CITY OF ALBUQUERQUE

May 16, 2025

**RE: Velasquez Residence
8701 Glendale NE
Grading & Drainage Plan
Engineer's Stamp Date: 5/8/25
Hydrology File: B20D069
Case # HYDR-2025-00161**

Based upon the information provided in your submittal received 5/8/2025, the Grading & Drainage Plan **is not approved** for Building Permit. The following comments need to be addressed for approval of the above referenced project.

ENGINEER'S SEAL	LOT 24 BLK 16 U 3 NAA 8701 GLENDALE AVE. NE	DRAWN BY DEM
DAVID SOULE REGISTERED PROFESSIONAL ENGINEER 14522	GRADING AND DRAINAGE PLAN	DATE 11-1-24
5/28/25	Rio Grande Engineering	8701 Glendale Ave NE, DING
DAVID SOULE P.E. #14522	ALBUQUERQUE, NM 87199 (505) 321-8099	SHEET # C1
		JOB #

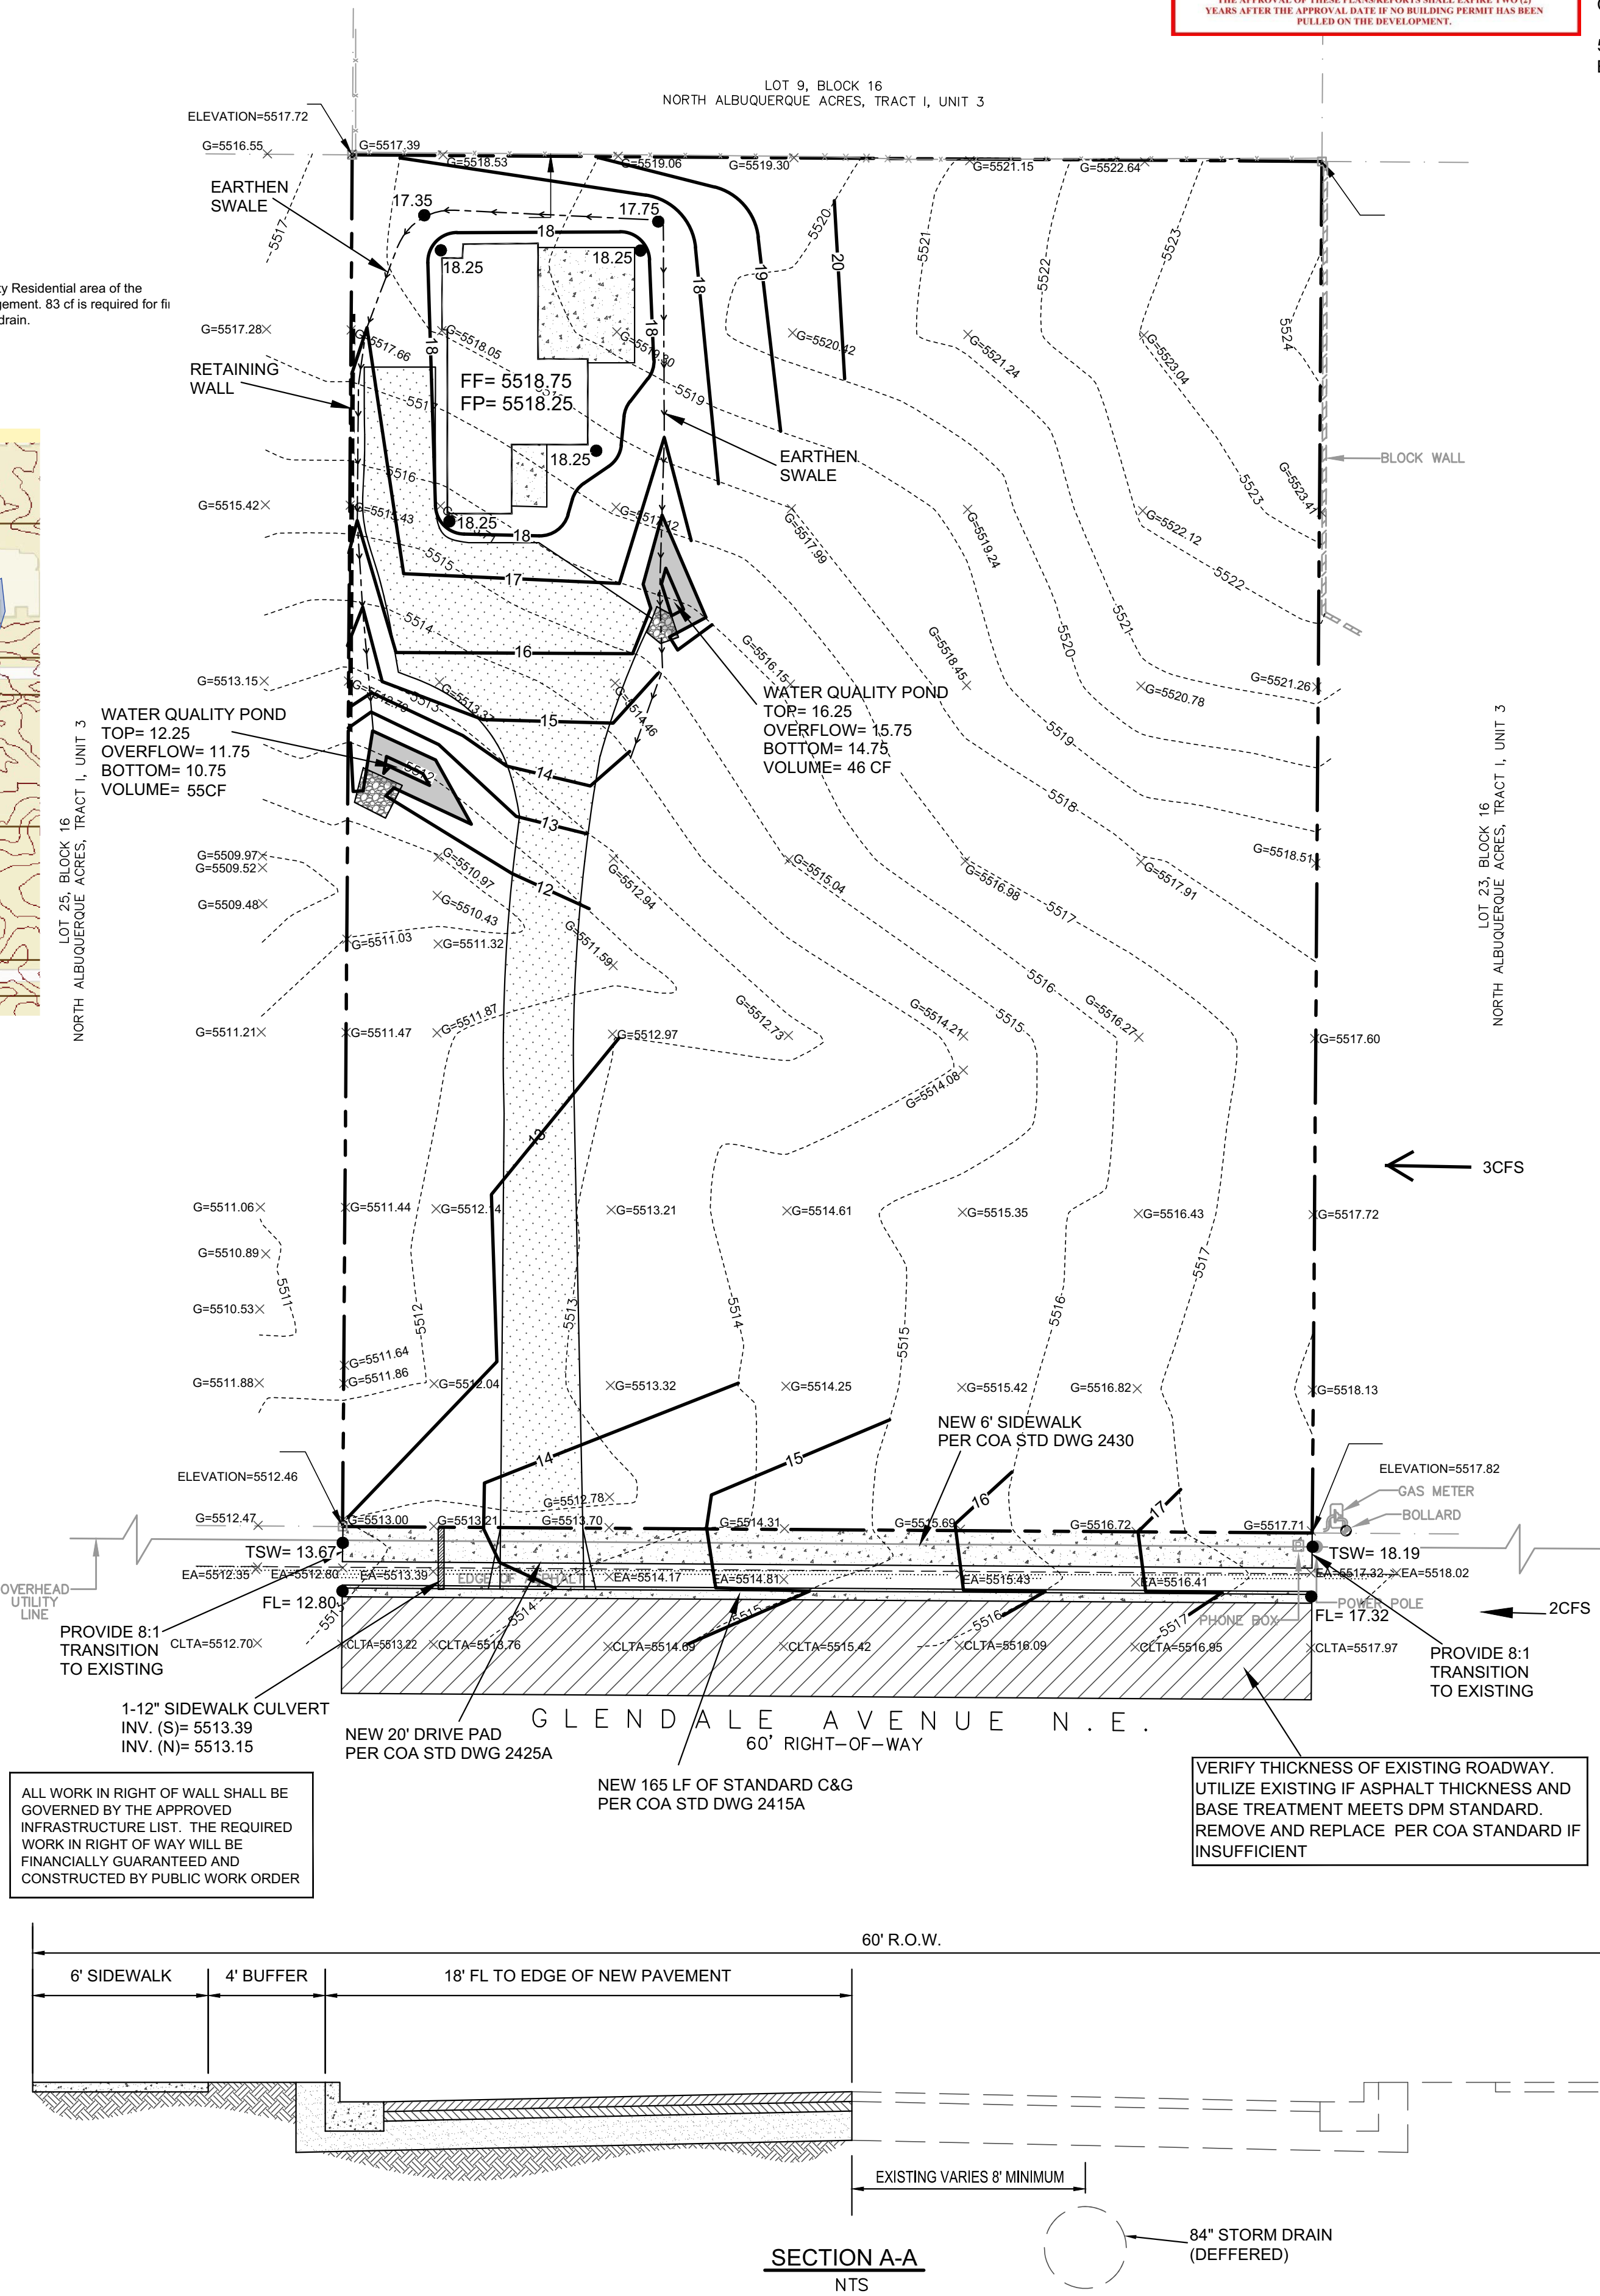
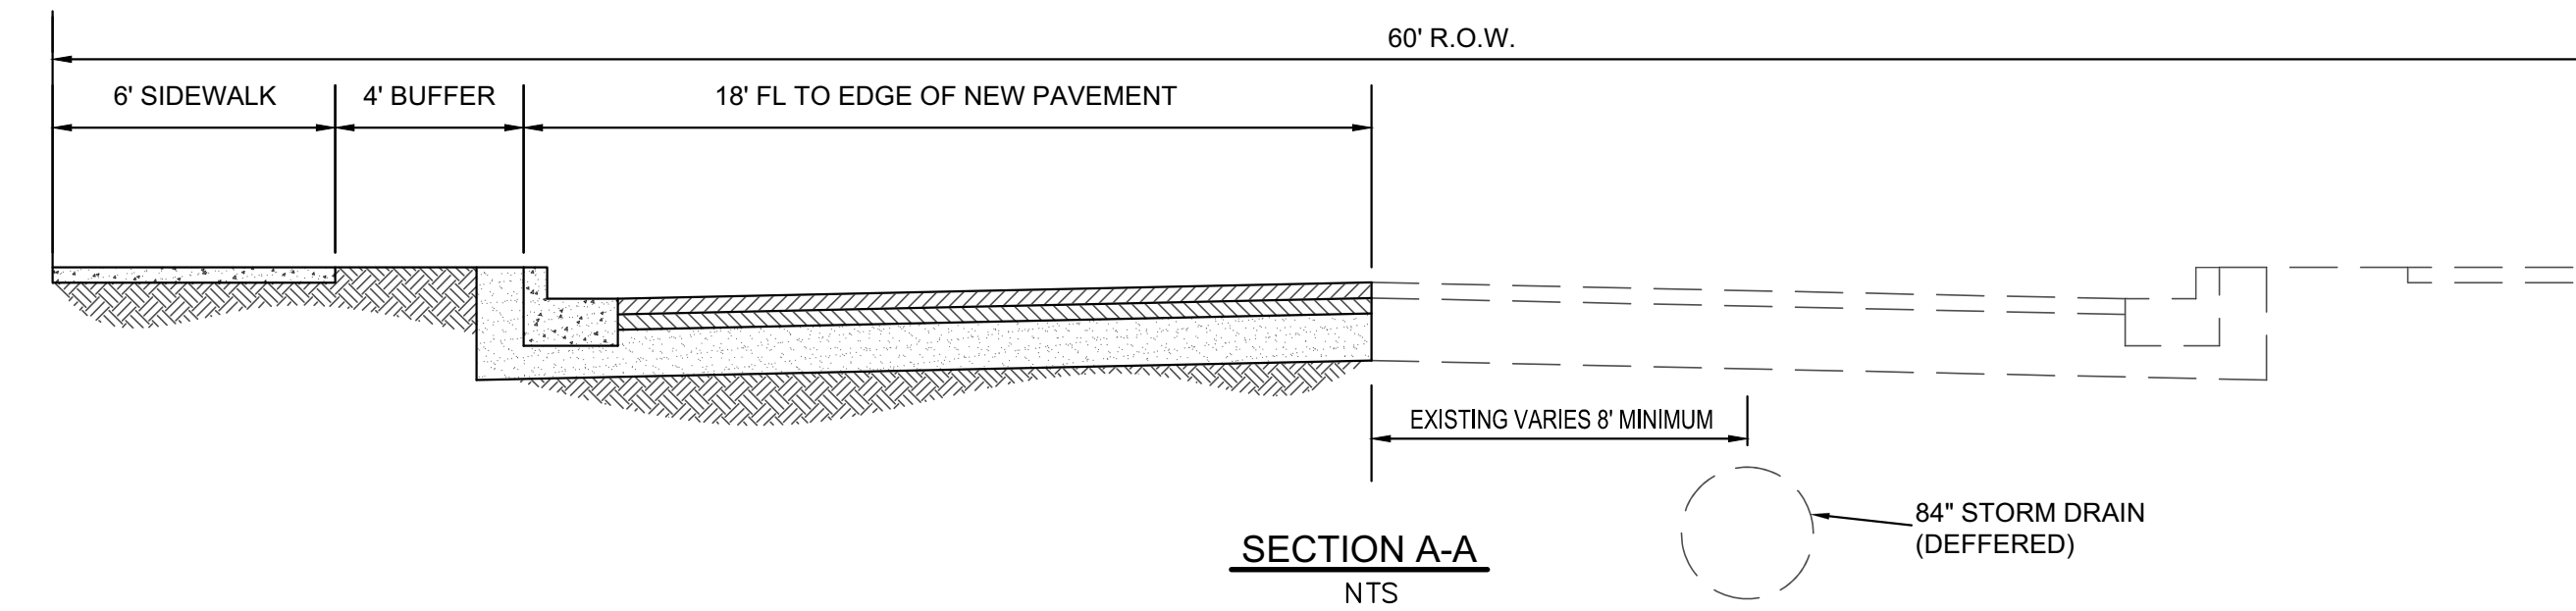
1. Per the IDO, the property owner of the property is responsible for building the adjacent half of Glendale Ave. NE to include curb & gutter, and sidewalk. The project will have to go to the Development Facilitation Team (DFT) for approval of the Infrastructure List. Also, half of an 84" storm sewer will also need to added to the Infrastructure List.
2. The curb & gutter, and sidewalk improvements will need to be shown on the Grading & Drainage Plan.
